Online Comment

Application H09-0867-19
Location Land off: Balmoral Way Holbeach Spalding
Proposal Details of Conditions 3, 4, 5, 6, 7, 8, 9, 10, 11, 13, 14, 15 and 16 of H09-0706-19)

Name Jeanette Reith
Address Environmental Protection - South Holland District Council

Date Submitted 18-03-23
For/Against Comments

Typical Strip Section A-A
scale 1:20

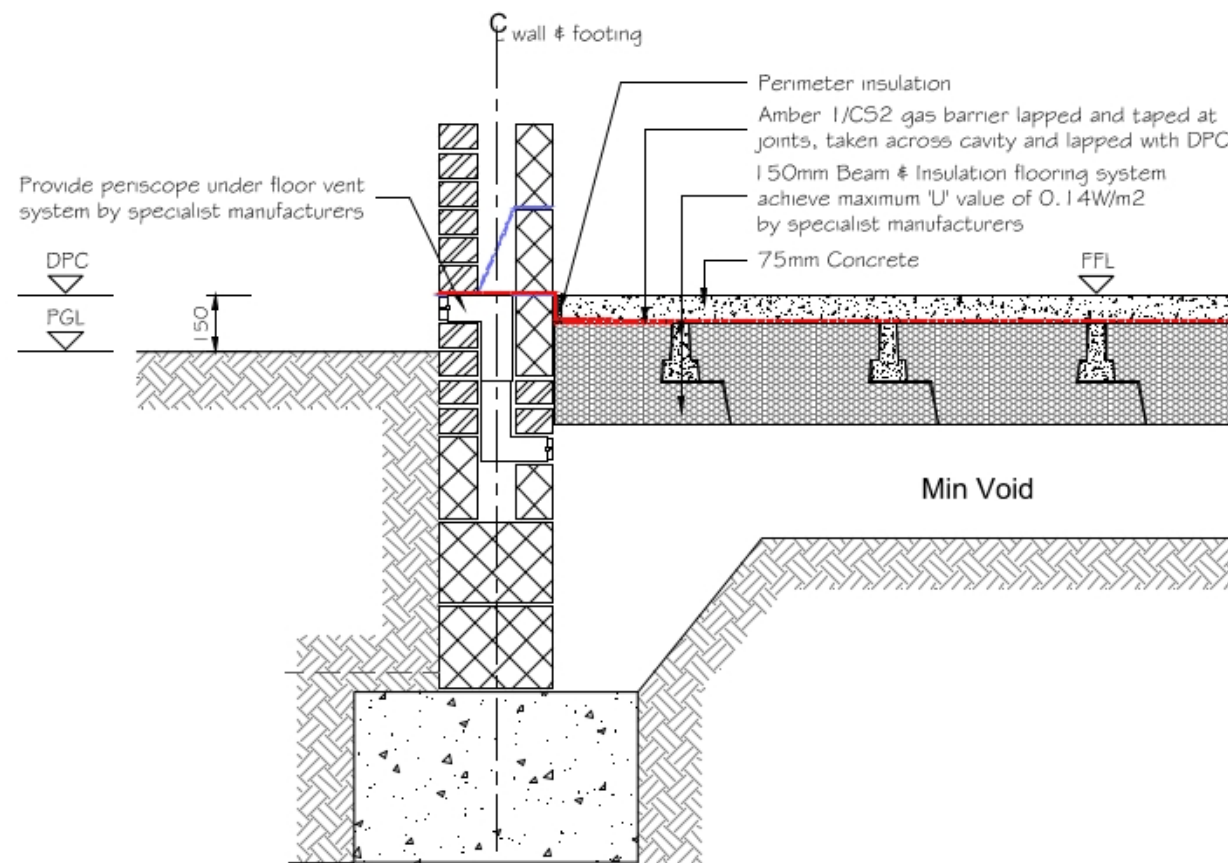
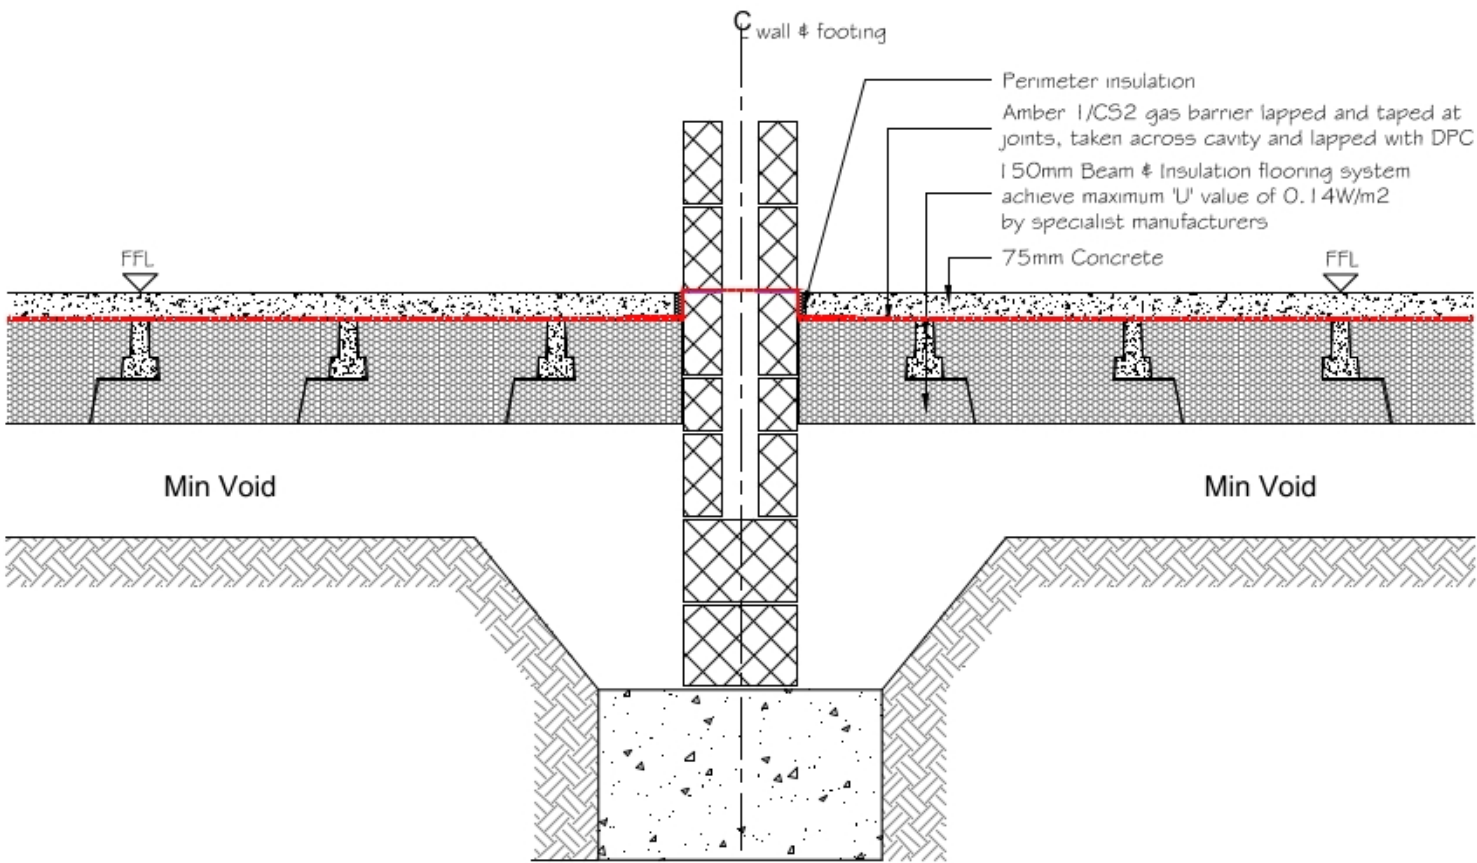
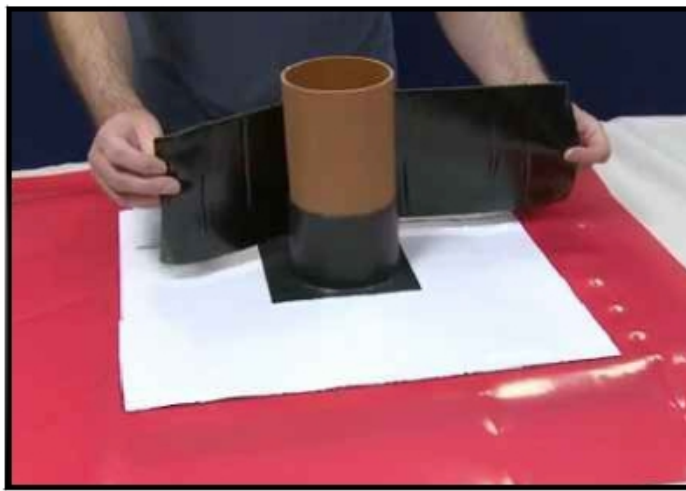
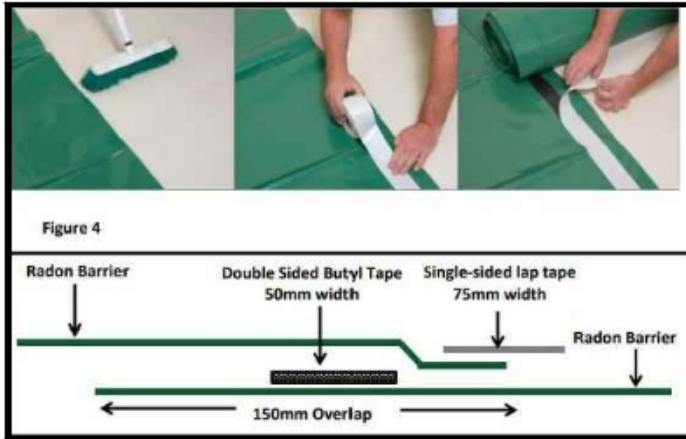
This supplementary report does not meet the verification requirements for gas protection measures as outlined in the technical guidance produced by YALPAG in 2016. For example, there are no plans or photographs, we do not know the competency of the installers or of the Harlor employee who carried out the visual inspection of the membranes. I appreciate that in retrospect it is not easy to evidence the installation process and that GeoDyne have stated that 'no further works or mitigation are necessary', however there are limitations to accepting information obtained from third parties.

With regards to verification of the ground gas protection measures, I recommend that the report provides further evidence that the measures have been installed as outlined in the Supplementary Gas Report. I refer you to the YALPAG Verification Requirements for Gas Protection Systems document dated December 2016. I would suggest including photographs of the protection measures during construction, where possible, and as completed. Also, any correspondence from the NHBC, Building Inspectors or Harlor that back up the specification of the protection measures that were installed and the competency of the persons involved in the process.
